Response to Planning application from Hertfordshire County Council (T and CP GDP Order 2015)

District ref: 6/2022/2811/ADV
HCC ref: WH/16084/2023
HCC received: 16 March 2023
Area manager: Manjinder Sehmi
Case officer: Senober Khan

15 Howardsgate Welwyn Garden City AL8 6BU

Installation of x2 non-illuminated signs, 1 externally illuminated sign, retractable canopy, barriers at front of the restaurant and 1 externally illuminated projection sign (retrospective)

Proposed Ground Floor Plan

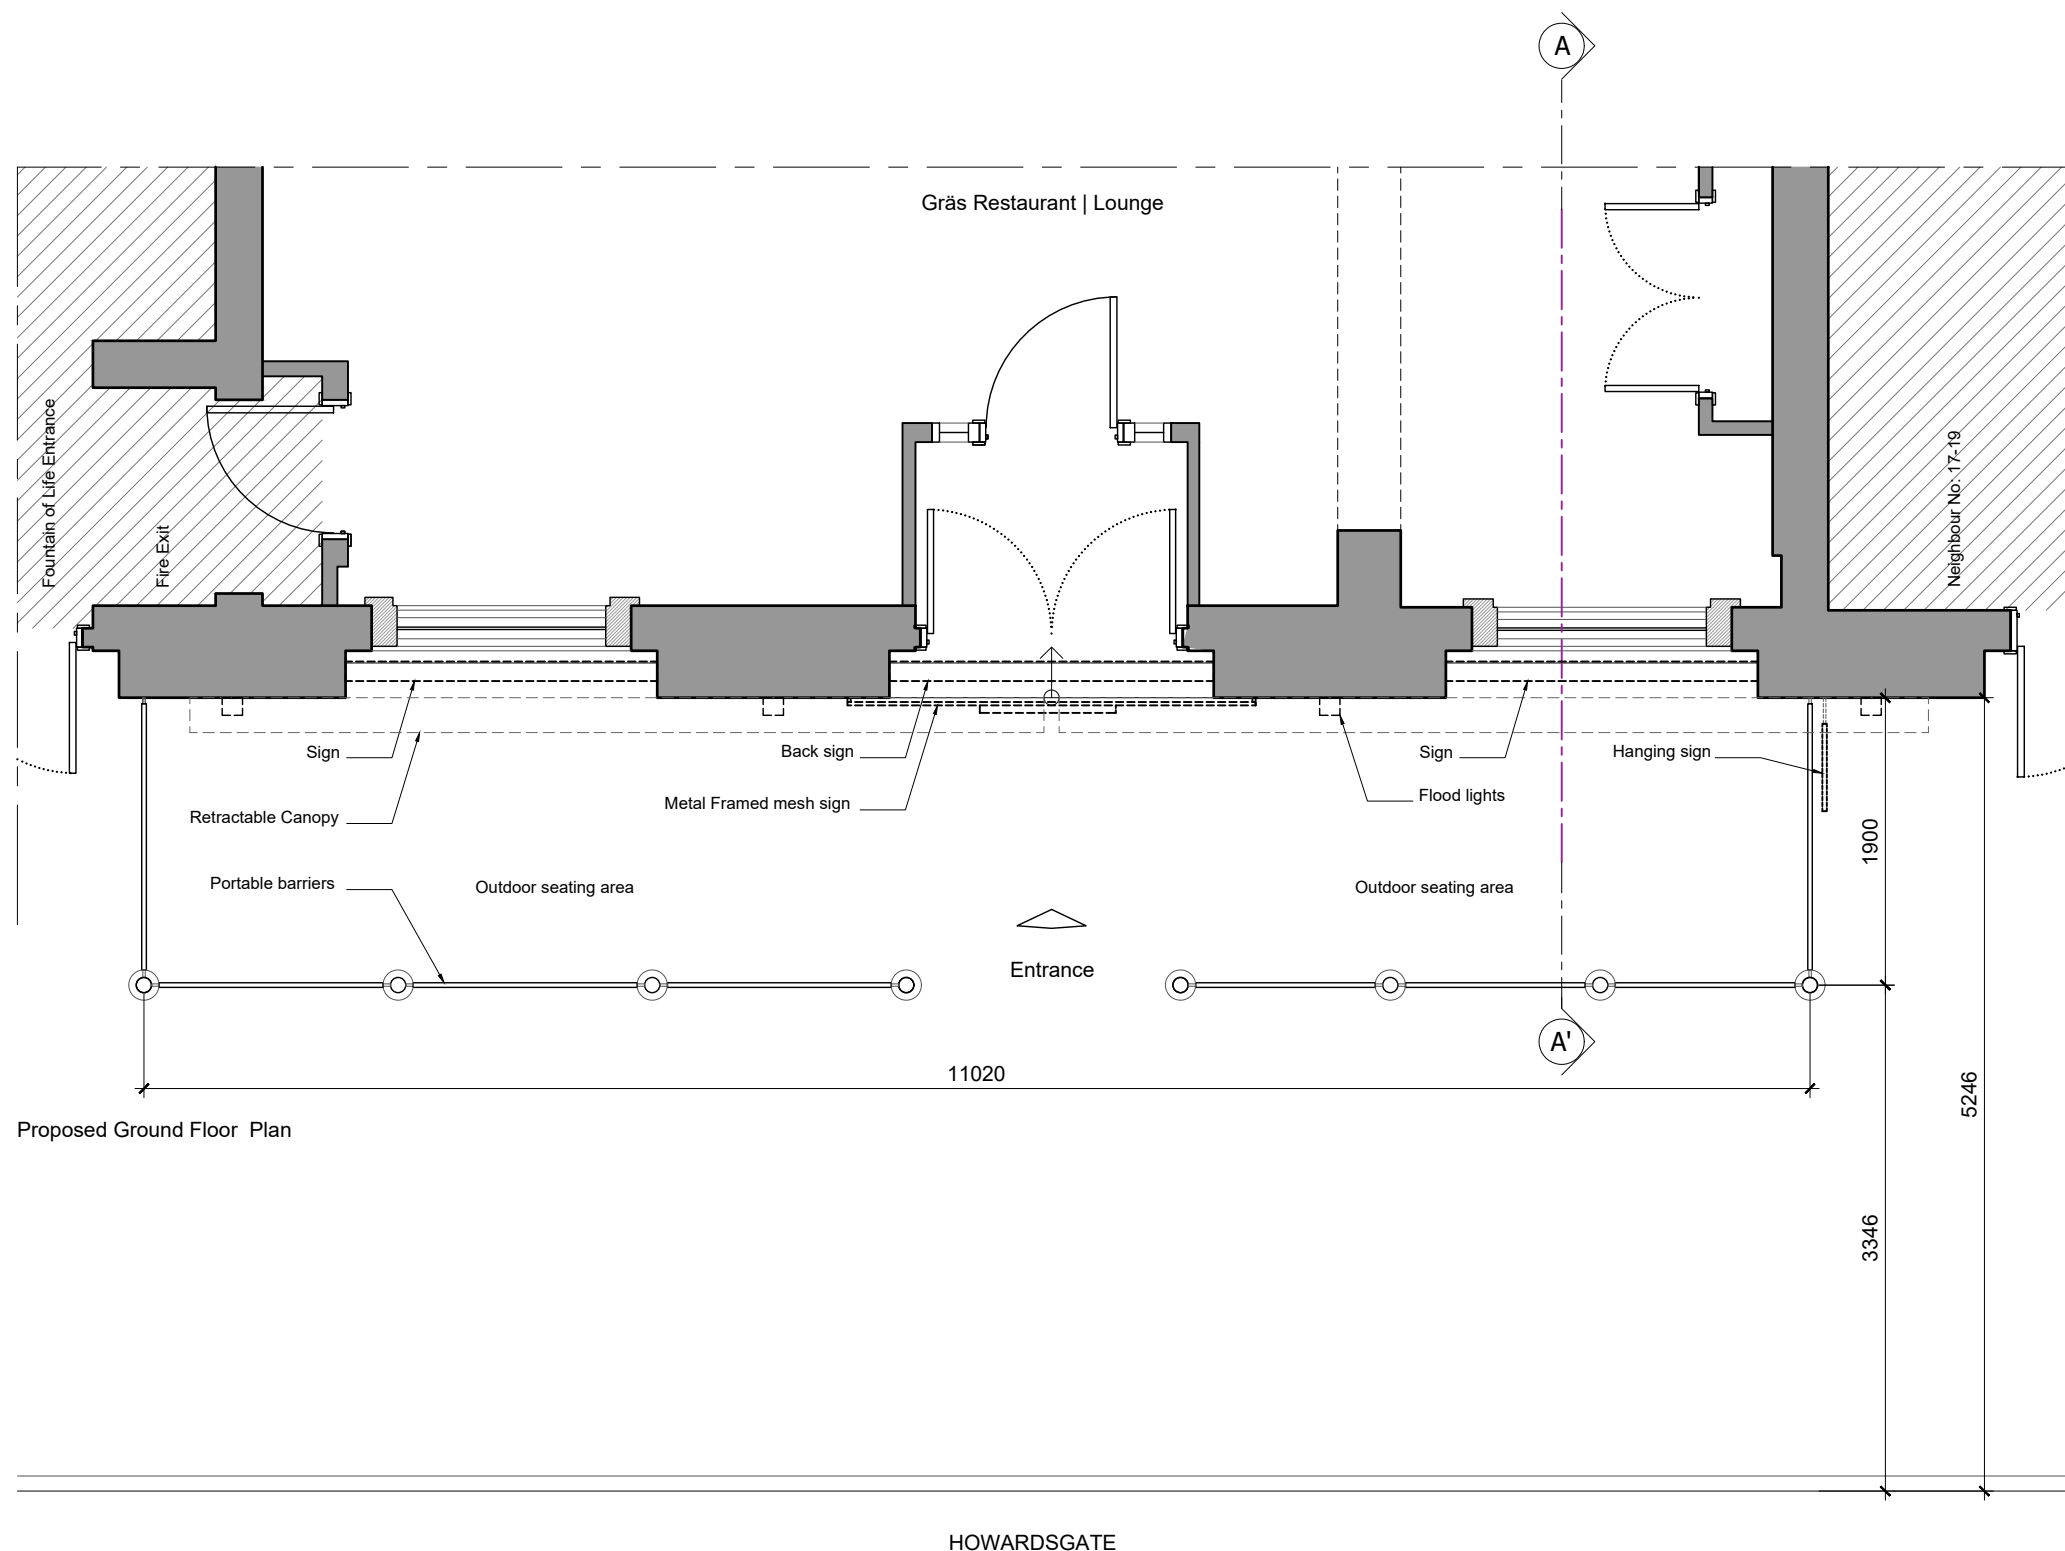
The proposal involves the installation of portable barriers placed around the street furniture consisting of tables and chairs along the full length of the sites frontage and extending out by 1.9m from the sites frontage. Given the footway width on the submitted plan is shown to be 5.246m and 1.9m is required for portable barrier/outside seating this would result in 3.346m wide unobstructed footway path.

Whilst clutter free pedestrian footways are preferred, however given the relatively wide footway at the proposed sites location, the proposed portable barrier/tables and chairs will result in an unobstructed pedestrian path of more than 3m in width. Street furniture/tables and chairs in locations in the town centre are acceptable provided that at least 3m width of unobstructed pedestrian paths are available.

Therefore, given there is a tolerable width of 3.346m for pedestrians to use, the proposals is not expected to have any significant detrimental impact on pedestrian safety, flow, movements or comfort.

The development hereby approved shall keep any street furniture consisting of tables/chairs/ancillary strictly within the area line in accordance with the approved plan, and then removed at the end of trading to safeguard pedestrian movement and from becoming a permanent feature on the footway.

The HA would not raise any objection for granting a café pavement licence for tables, chairs and ancillaries subject to being removed at the end of trading to safeguard pedestrian movement and from becoming a permanent feature on the footway.
